From: chris [REDACTED]
Sent: 15 December 2014 07:41
To: Planning.Responses; Daun Johnson
Cc: Planning
Subject: RE: Further Information Required on Your Ref: PP-03831910 Our Ref: Y/101/14/HH

Site Plan (scale 1:500)

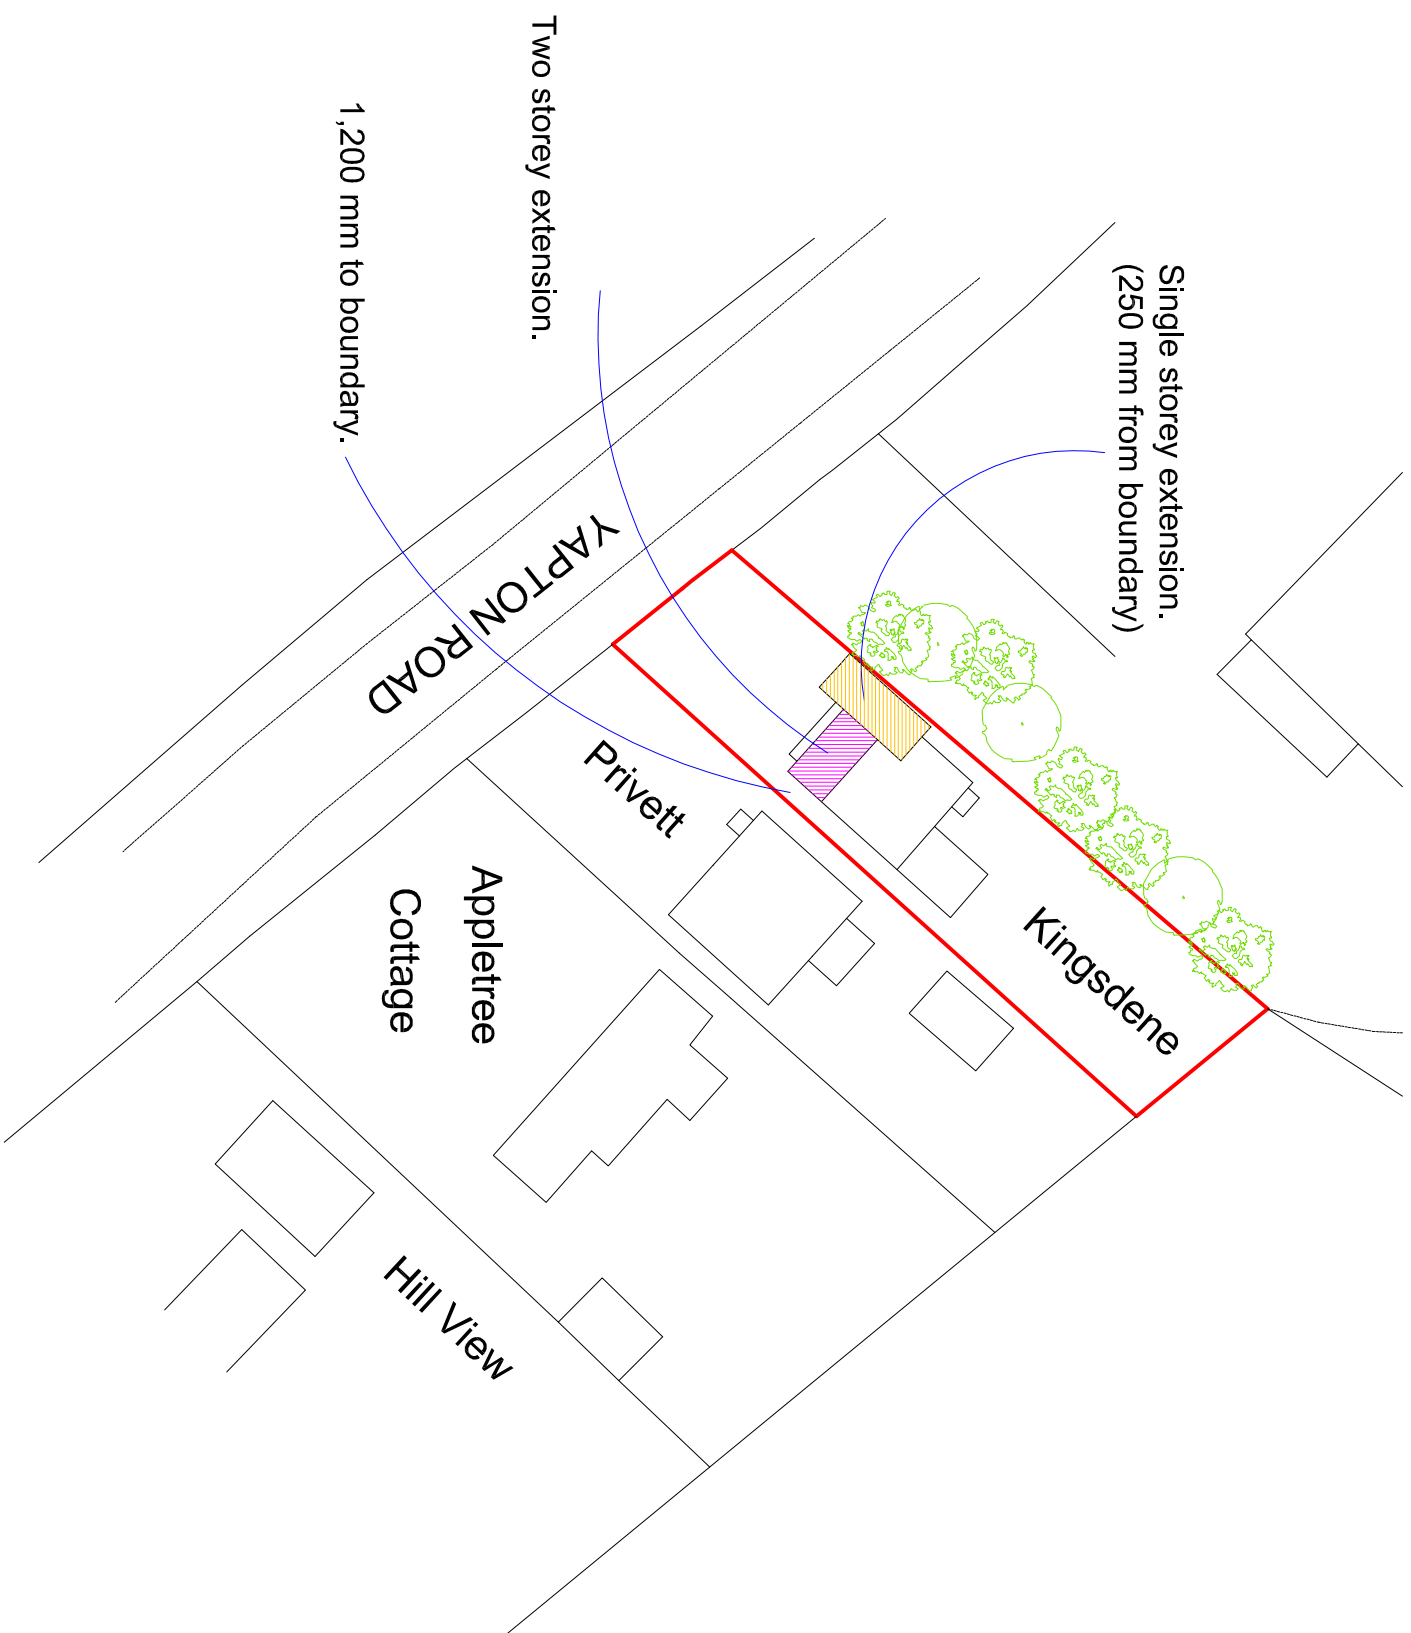
I trust this answers your query relating to the Lidsey Drainage Catchment Area.

I can confirm that the new extension and foul water drainage will connect to the existing mains foul water system as shown on the site plan.
